Application by Equinor for an Order Granting Development Consent for the Sheringham and Dudgeon Extension Projects.

Examination Timetable – Deadline 4

Comments on Applicant's submission at Deadline 3

The Applicant provided a Navigation Safety Technical Note (document reference 6.3.13.2) in response to the Examiner's Questions 2 on issues highlighted during the Issue Specific Hearing (ISH) 6 and we would like to respond to specific points as follows:

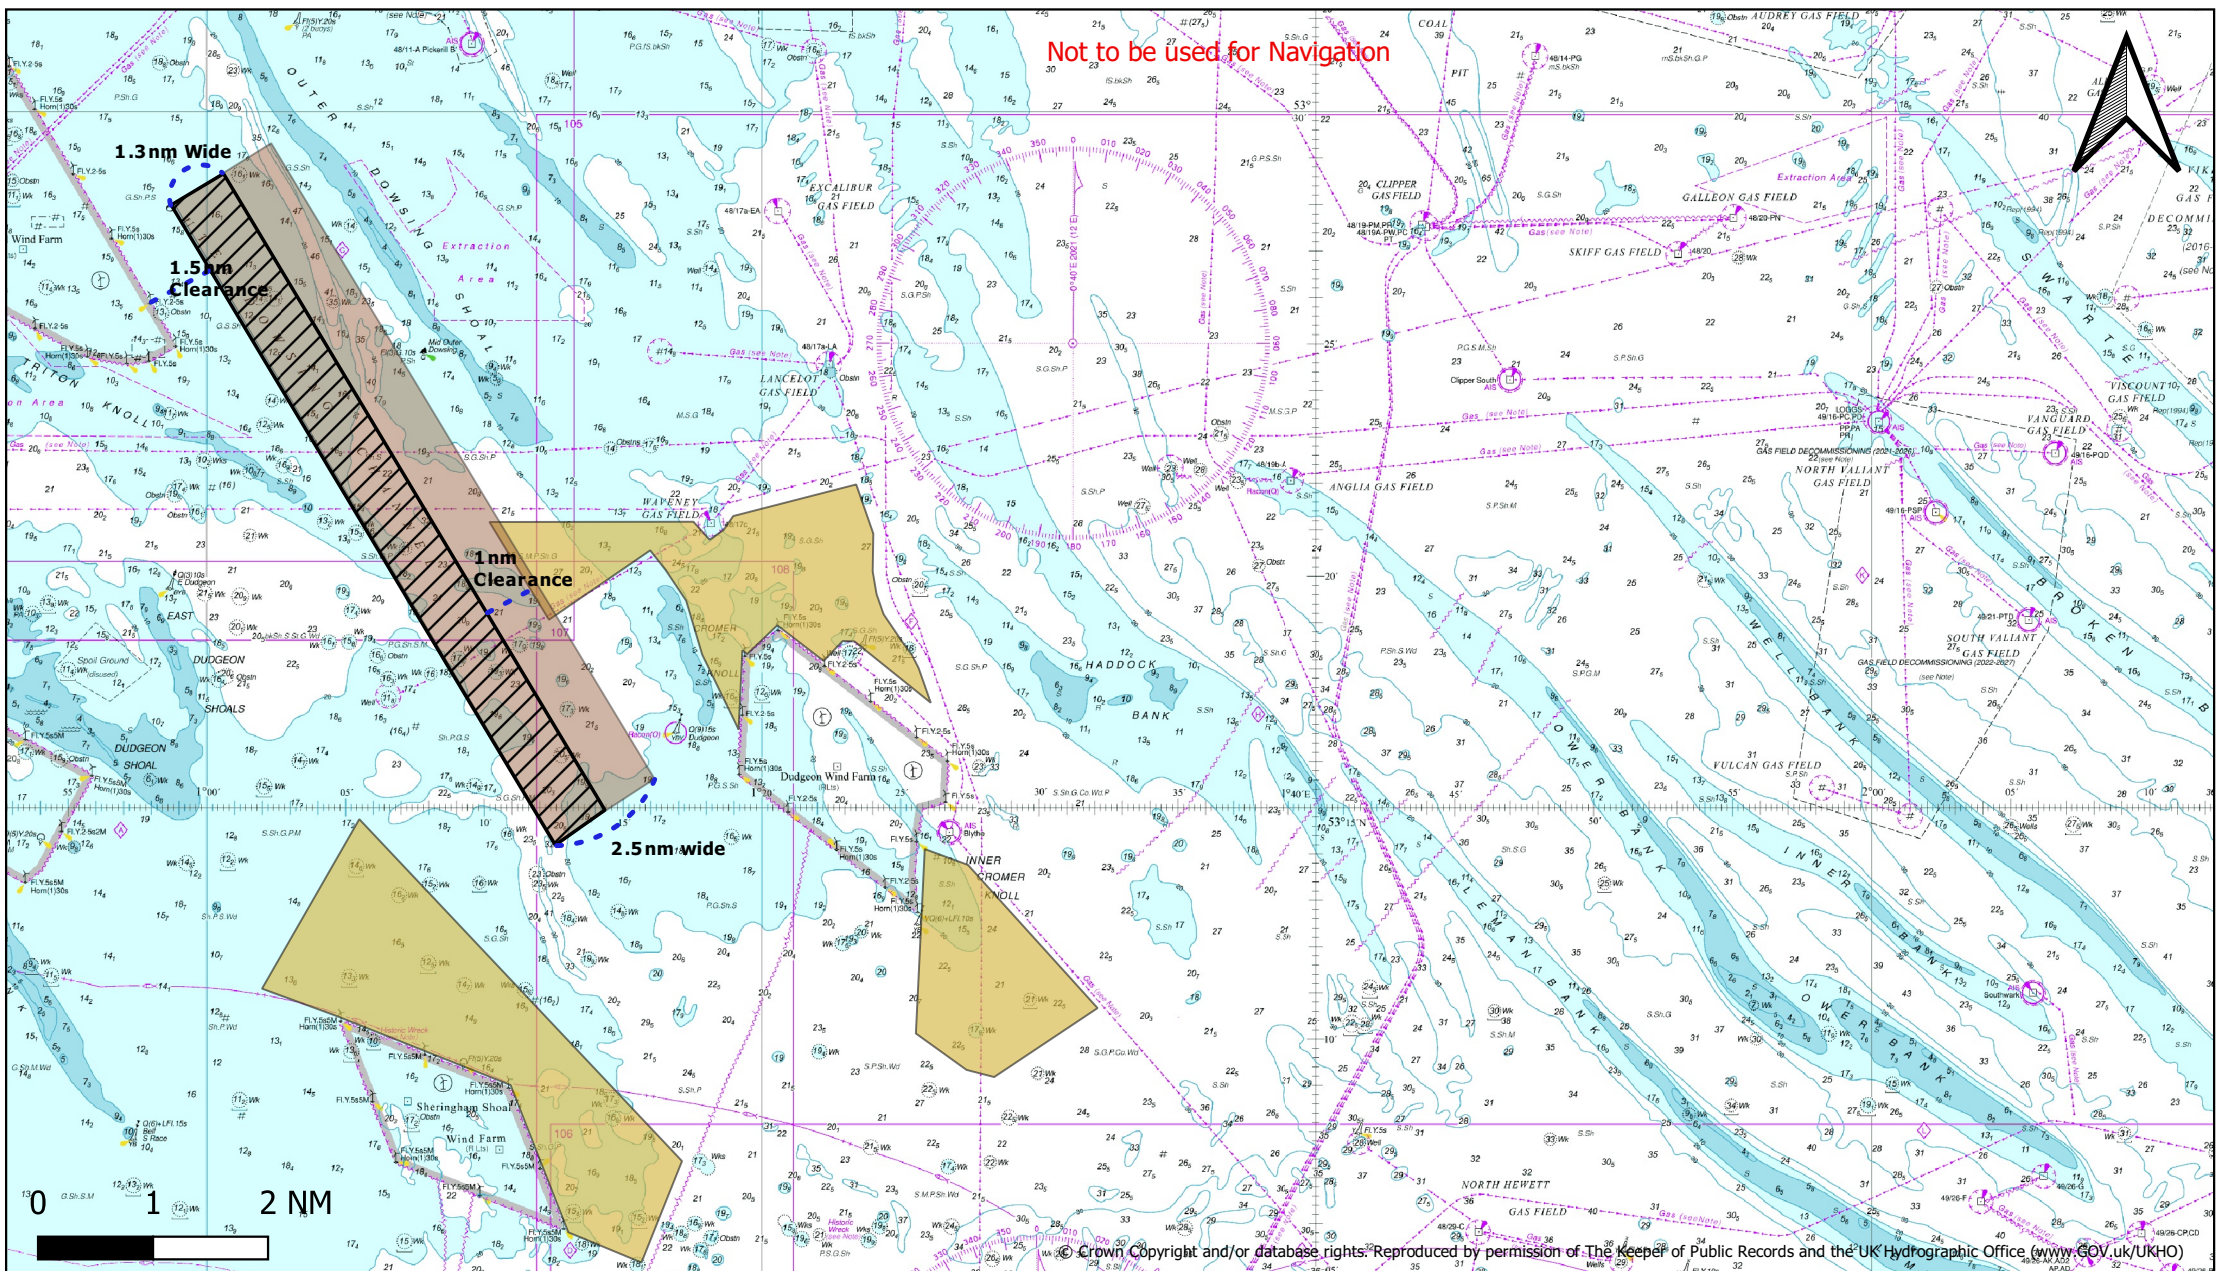
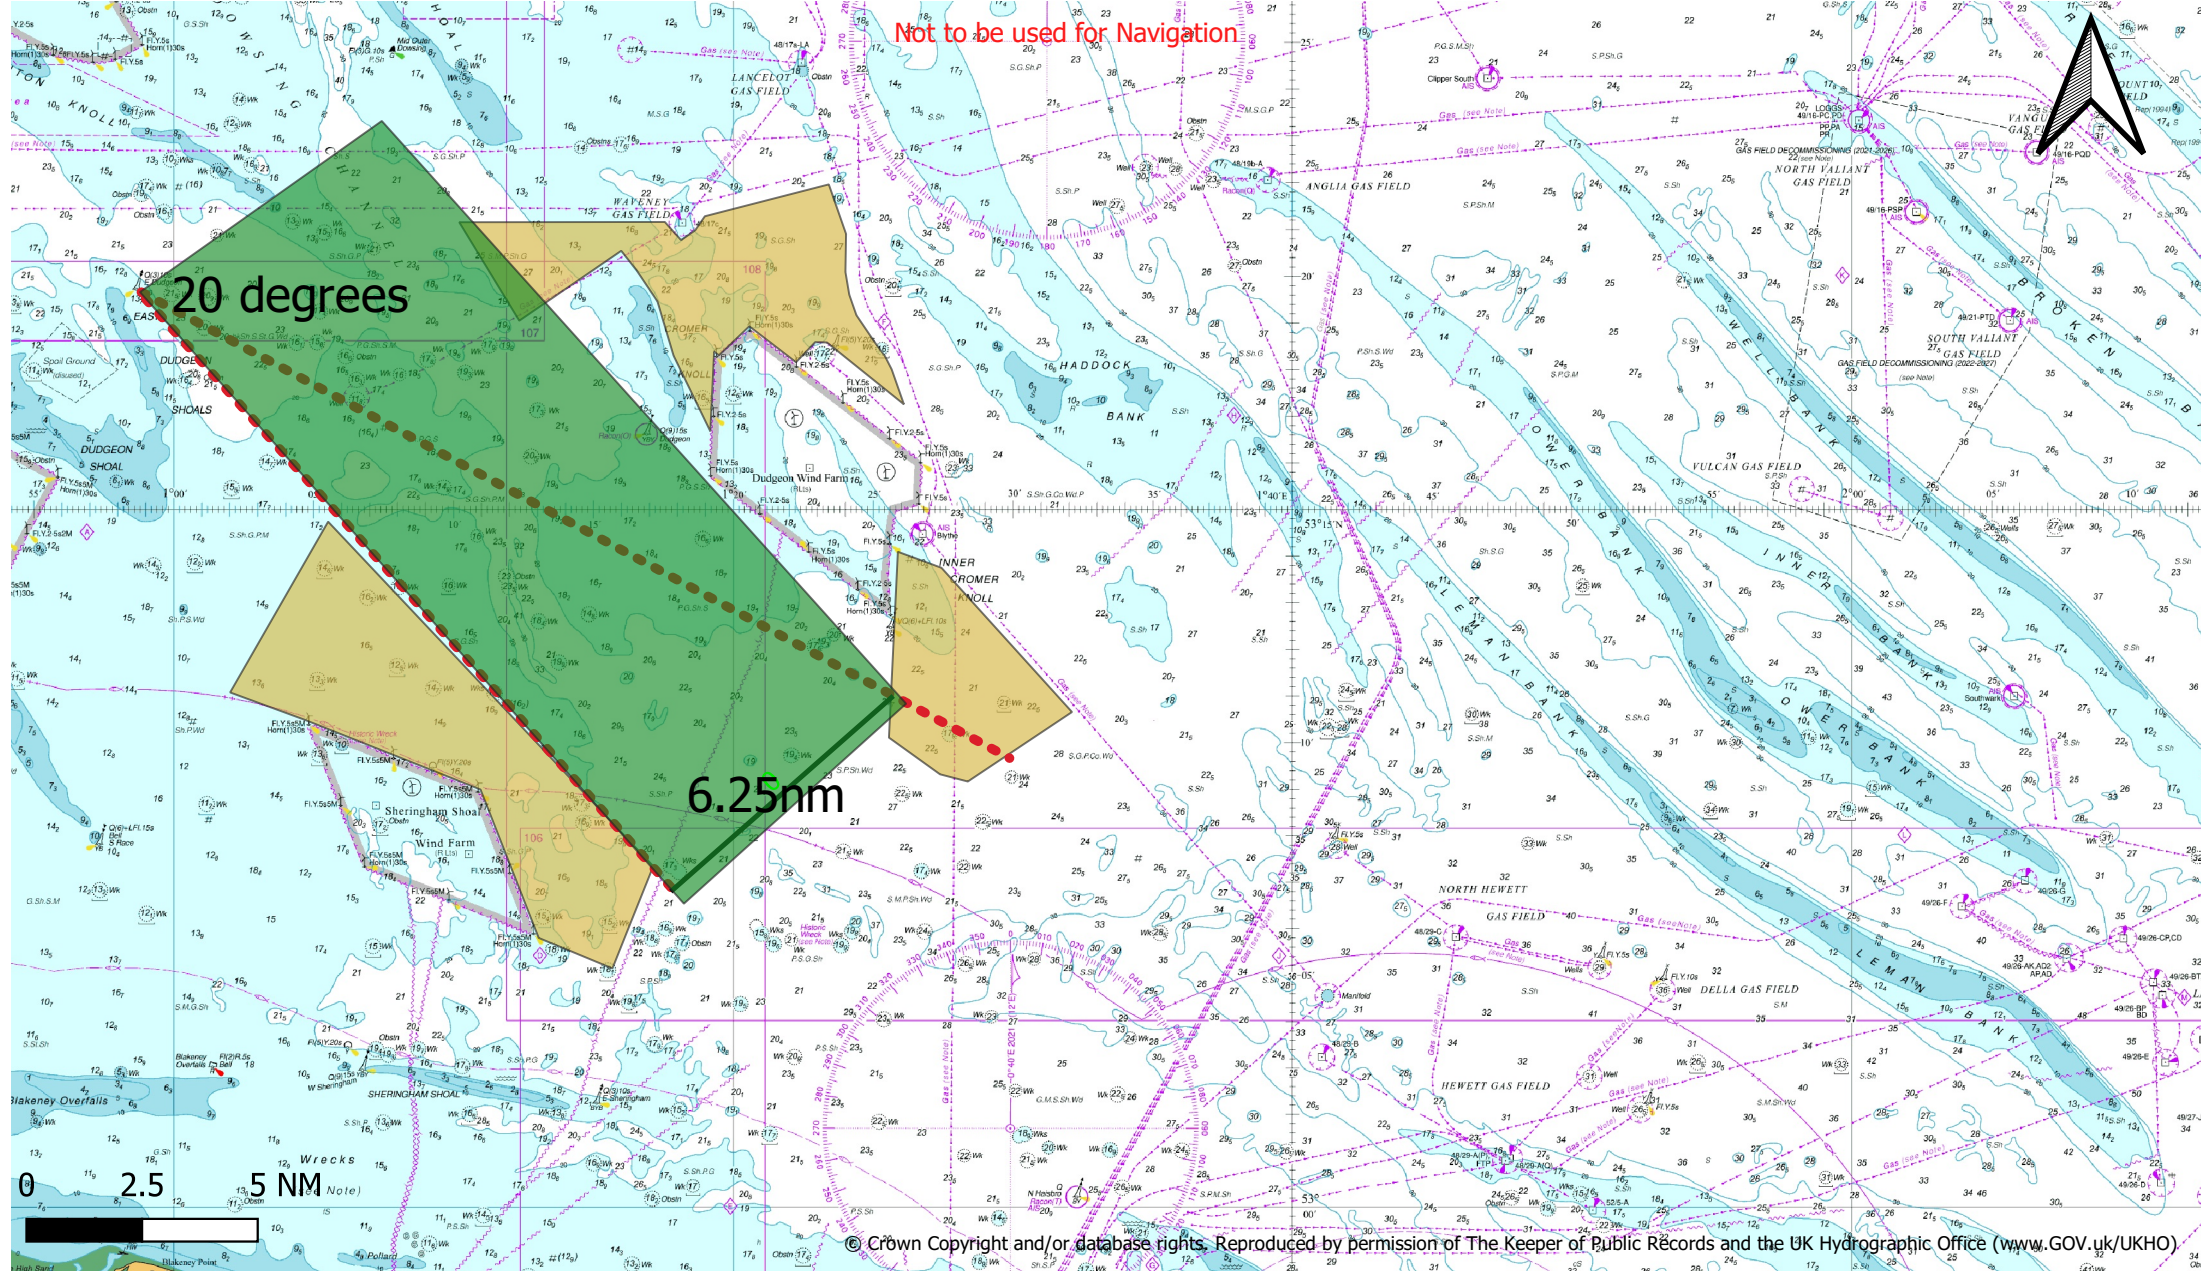
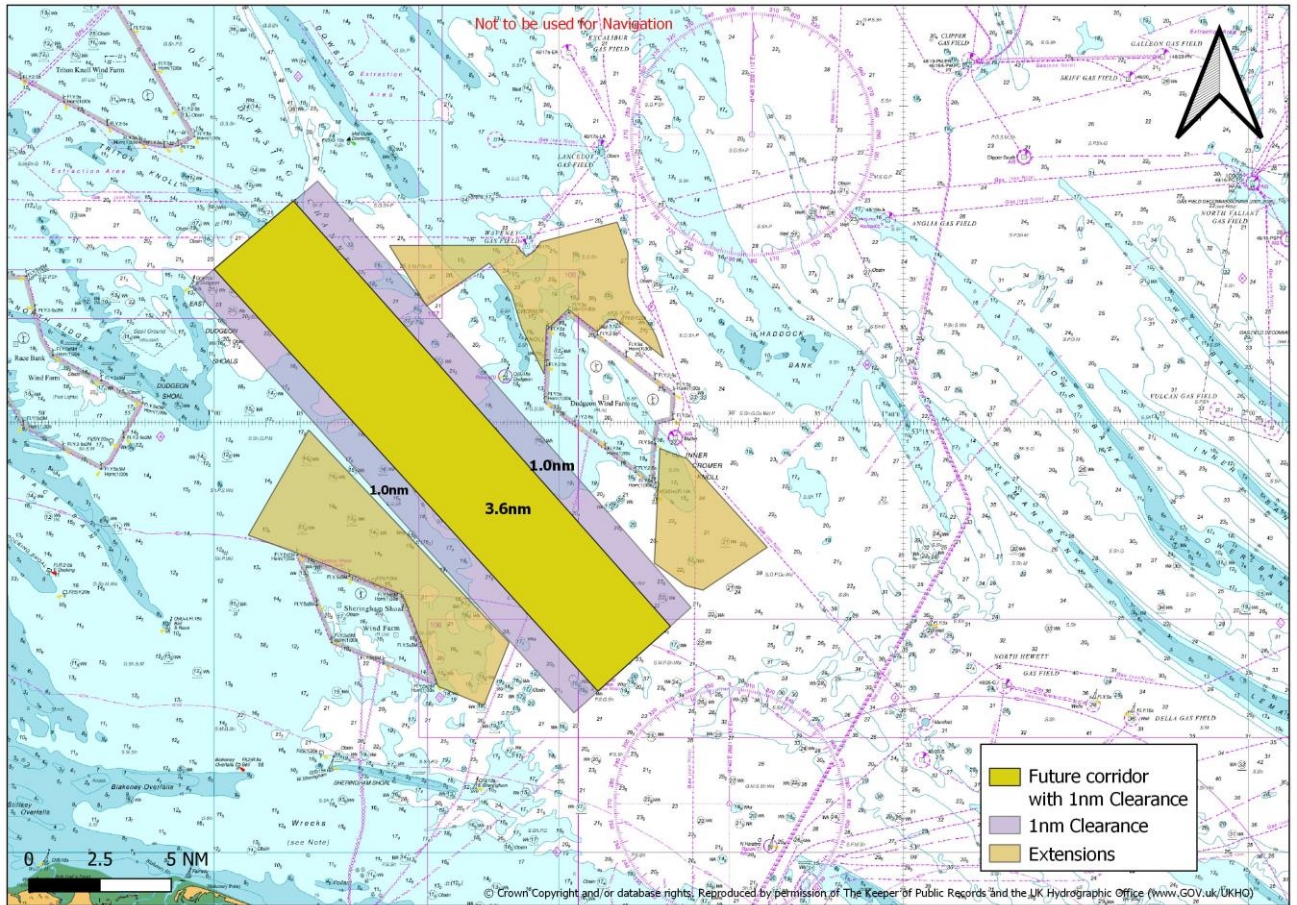
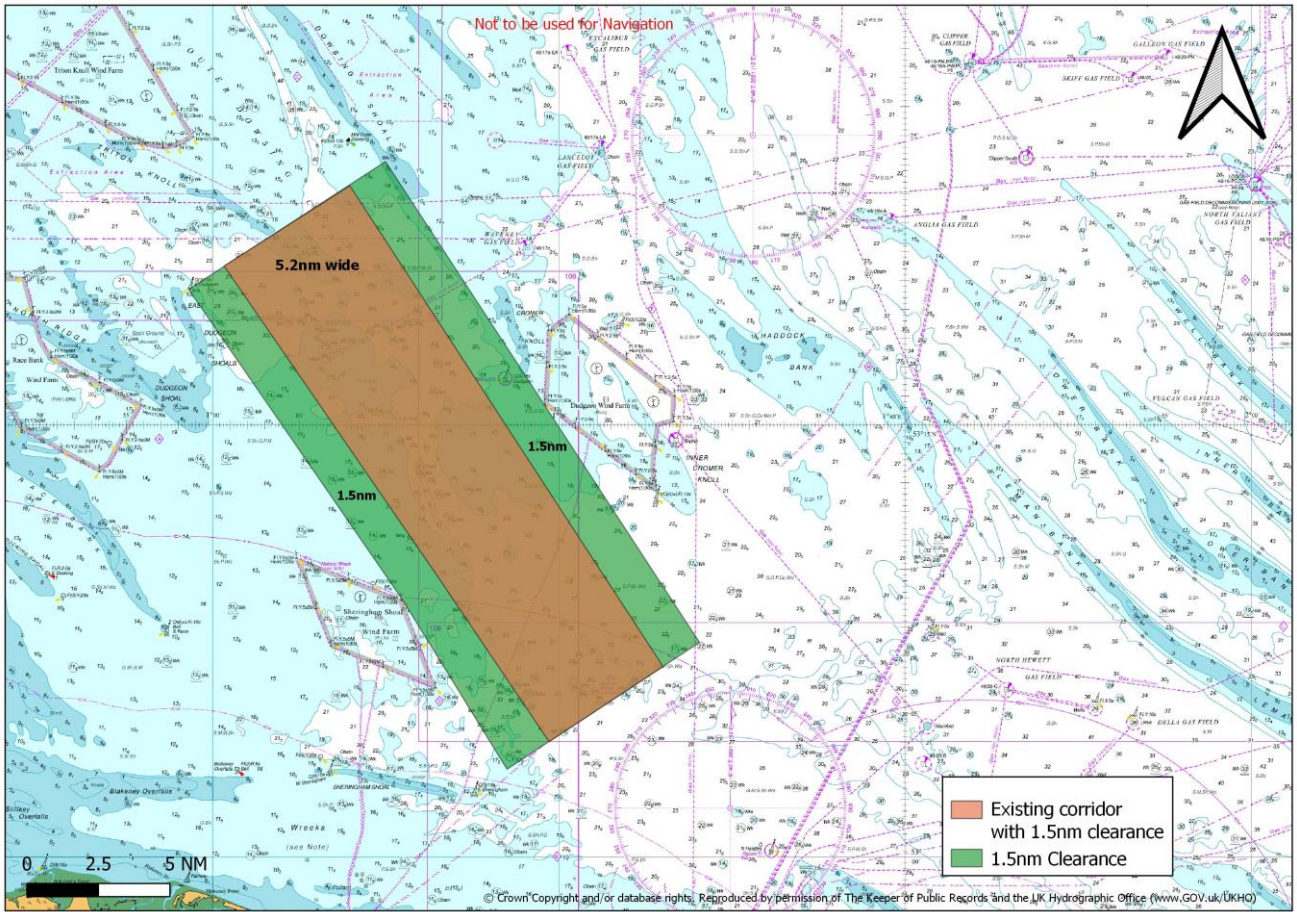
<p>Table 7.2 concludes the collision risk will only change by 3% with the removal of the western boundary of DEP North. However, MCA does not believe this is a reasonable conclusion as the future extent of the traffic (future channel width) has not been represented with both safety buffers and more condensed traffic, and we are testing it against qualitative factors of good seamanship and</p>	Scenario	Change in collision risk	Base Case (0% traffic increase)	11.5%	10% traffic increase	11.4%	20% traffic increase	11.9%
Scenario	Change in collision risk									
Base Case (0% traffic increase)	11.5%									
10% traffic increase	11.4%									
20% traffic increase	11.9%

Chapter	Applicant comments	MCA response
		<p>compliance with COLREG i.e. collision avoidance in head on and converging traffic situations. The narrowing of the channel limits mariners' options for taking early and substantial avoiding action if a collision scenario is identified. Collision risk change for the entire area is more than 11% and we would expect a higher change of collision risk than 3% off the DEP North area.</p>
<p>8 Existing Precedent Para 67</p>	<p>The Applicant notes that:</p> <ul style="list-style-type: none"> • Based on the vessel traffic survey data, the “Race Bank Channel” is busier than the traffic associated with the routes passing the northwest extent of the DEP windfarm site through the “Outer Dowsing Channel” (19 vessels per day compared to 13 vessels per day); • The vessels navigate through the “Race Bank Channel” in an area of searoom that is more restricted (i.e., narrower) than what will be available post wind farm at the northwest extent of the DEP windfarm site within the “Outer Dowsing Channel” (2.3nm vs 2.7nm); • The length of the “Race Bank Channel” is longer than the restricted area that will be present at the DEP windfarm site (8nm vs 3nm); and • There is no visible surface piercing hazard in the “Race Bank Channel” i.e., mariners rely on charted locations of the shallows and surface buoyage to safely navigate the area (for DEP-North, the wind turbine generators will be visible hazards). 	<p>The Race Bank channel is constricted by areas of shallow water and it is difficult to compare collision and allision risks to the area west of DEP North since this channel will be bordered by wind turbines where there will be higher allision risk. This in turn will influence seafarer behaviour by having a wider safety buffer which will constrict the traffic into a narrower channel and therefore collision risk will increase.</p>

Chapter	Applicant comments	MCA response
9 Summary Para 74	As noted in the NRA [APP-198] and this technical note, none of these routes are significantly impacted by the presence of SEP and DEP noting that safe sea room is maintained, and collision risk values are acceptable. This is supported by the consultation undertaken as part of the NRA process which demonstrates that general consensus was that Mariners do not have notable safety concerns about using the area in a future case environment (with SEP and DEP in situ).	Safe sea room will not be maintained in the channel west of DEP North. The safe sea room will be narrower and vessel traffic will be constricted.

There remains disagreement on the risks west of the DEP North boundary. The applicant maintains that navigational risk will not increase significantly and that there will be little change to the safe sea room. It is the MCA's opinion that navigational risk will increase in this area due to the reduced safe sea room and that mariners' ability to avoid a collision or allision as a result will be compromised.
